From: Bloomer, David <David.Bloomer@lancashire.gov.uk>
Sent: 24 January 2019 12:23
To: Adam Birkett
Cc: LHS Customer Service; planning
Subject: app/2019/0007 James Alpe, Lincoln Way , Clitheroe

PROPOSED PLANS AND ELEVATIONS

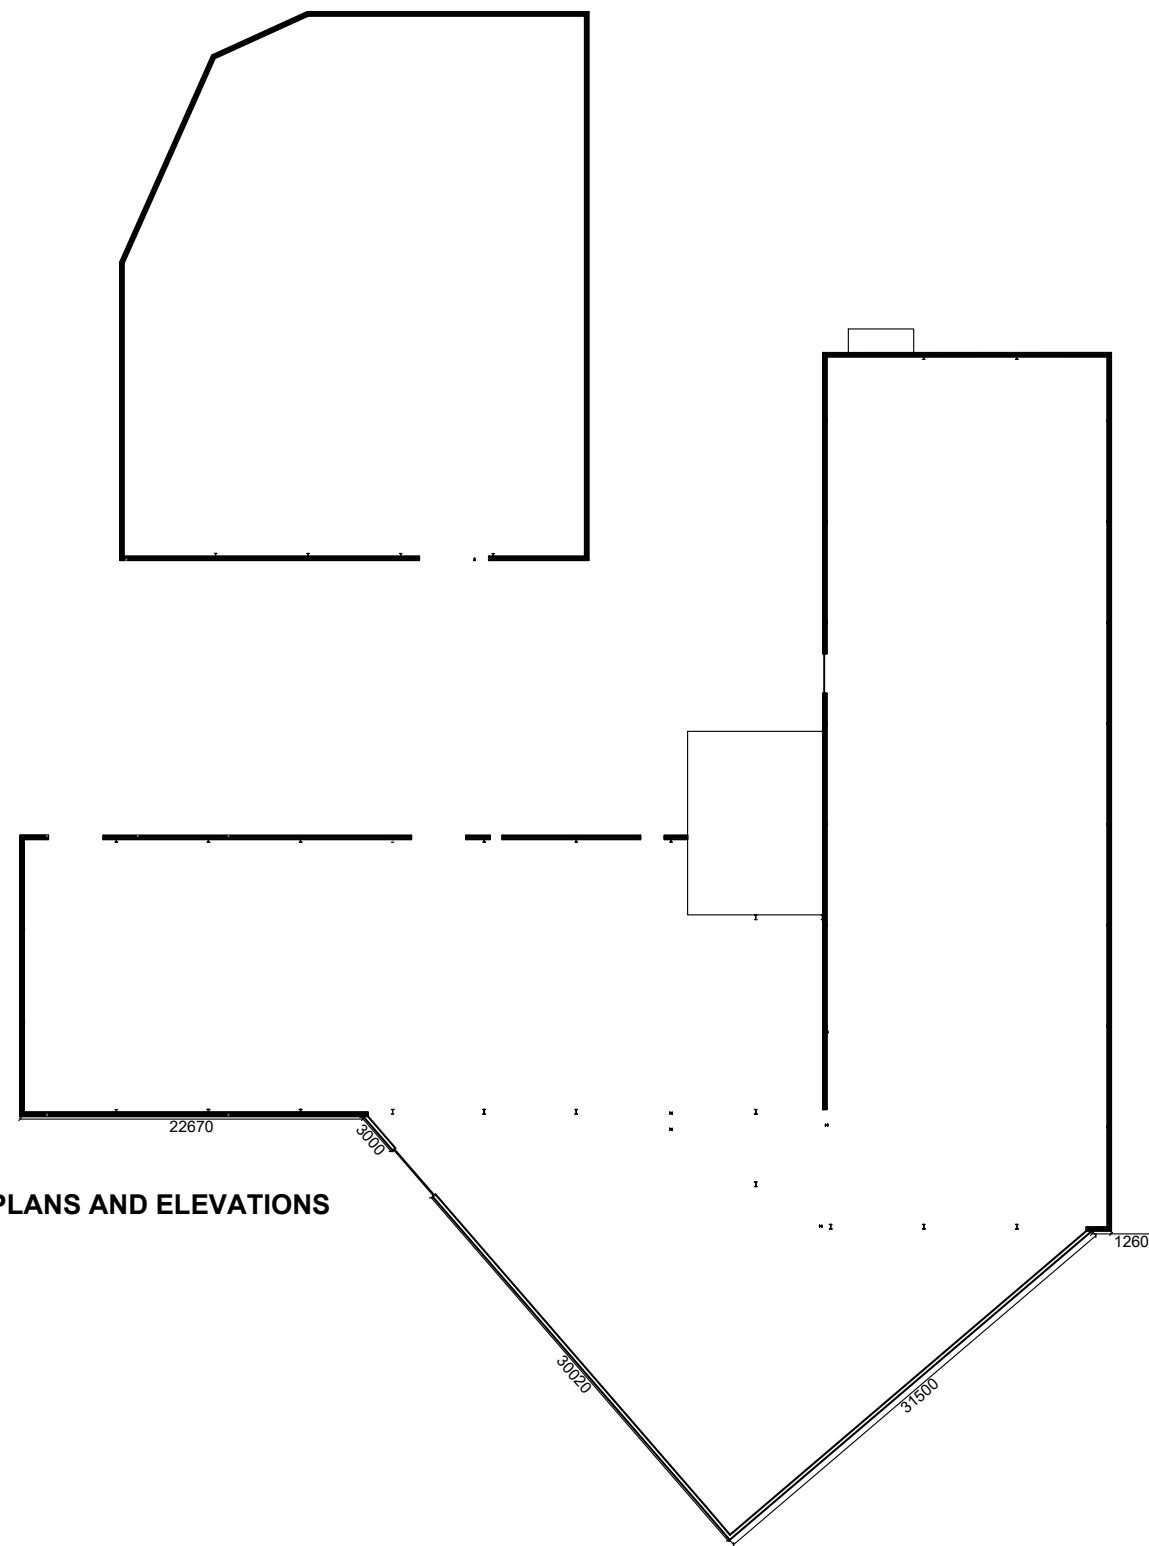
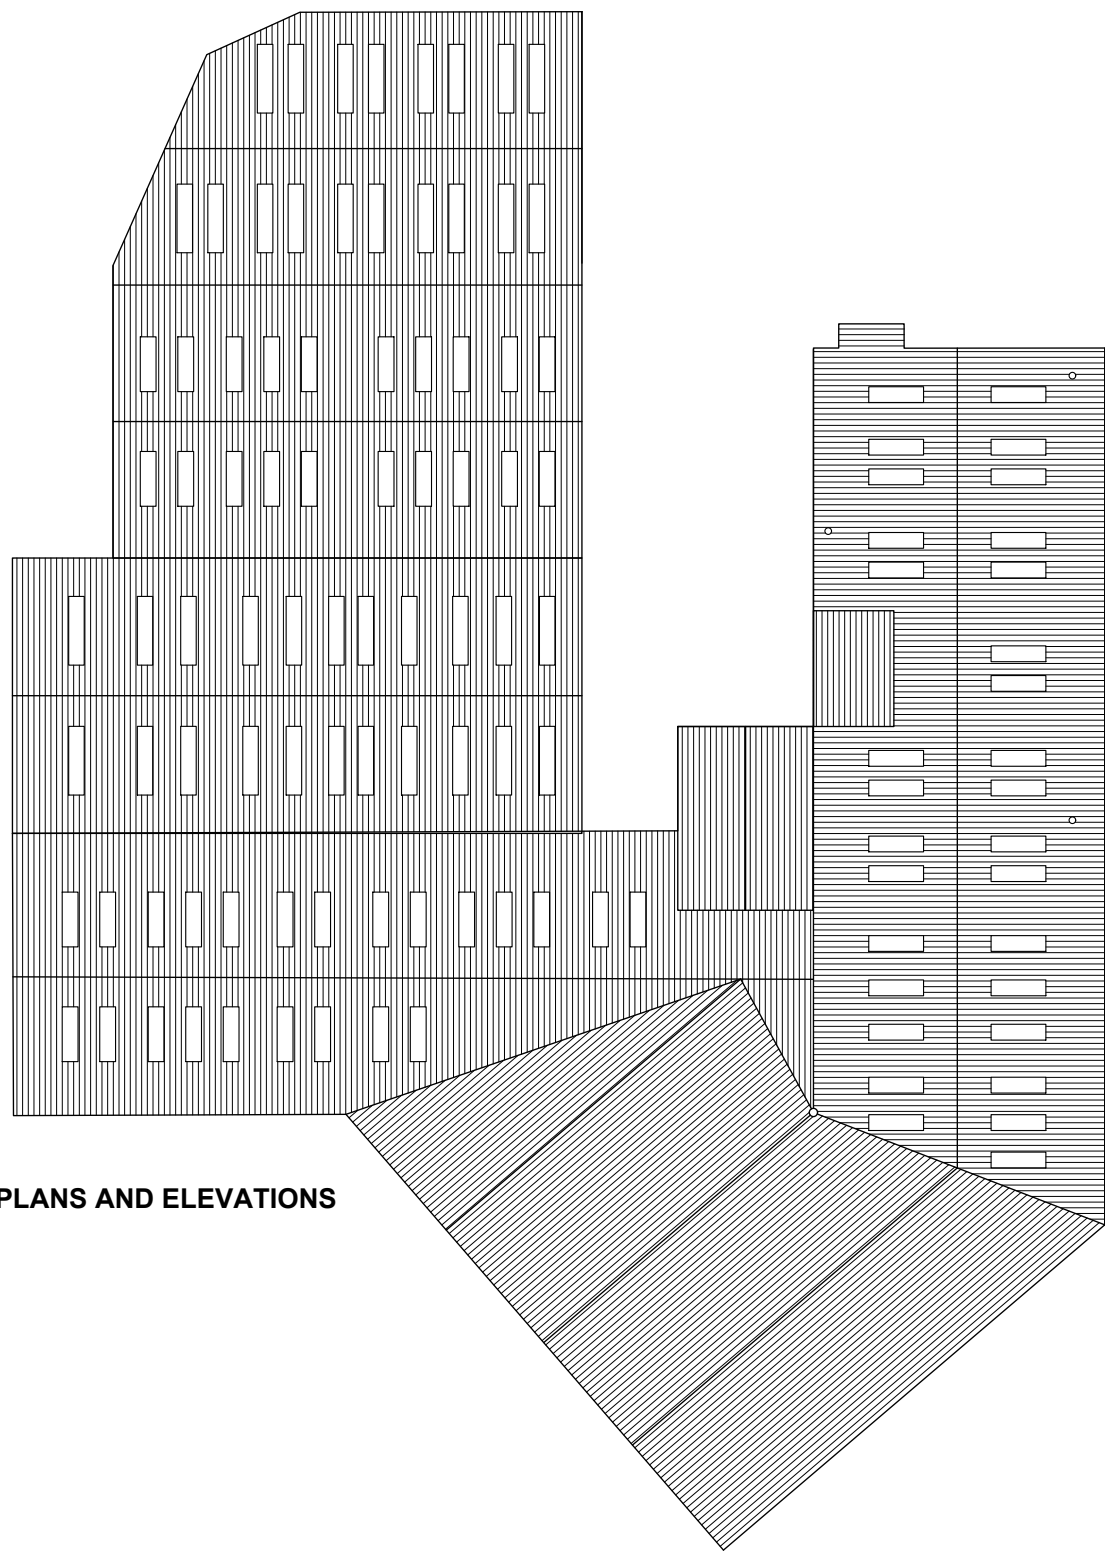
The proposal will increase the size of this facility which will be offset by the additional parking proposed and in this respect I would raise no objection to the proposal , however there are existing issues of on street parking between the entrance to the site and Lincoln Way and in this respect the development will increase vehicular traffic through this junction. In order to counter this and improve traffic flows and visibility I would like to see additional waiting restrictions introduced in this area and therefor would request that should your council be minded to approve this application the following conditions be attached to any permission that may be granted

1. The car park shall be surfaced or paved in accordance with a scheme to be approved by the Local Planning Authority and the car parking spaces and manoeuvring areas marked out in accordance with the approved plan, before the use of the premises hereby permitted becomes operative. Reason: To allow for the effective use of the parking areas.

2. There shall be no direct pedestrian or vehicular access between the site and Lincoln Way / Up Brooks and to that end a continuous wall or fence not less than 1.8m in height shall be erected before development commences and be permanently maintained on the highway boundary of Lincoln Way and Up Brooks all vehicular and pedestrian access being obtained from the main site entrance. Reason: To limit the number of access points to the highway network aiding to road safety and site security.
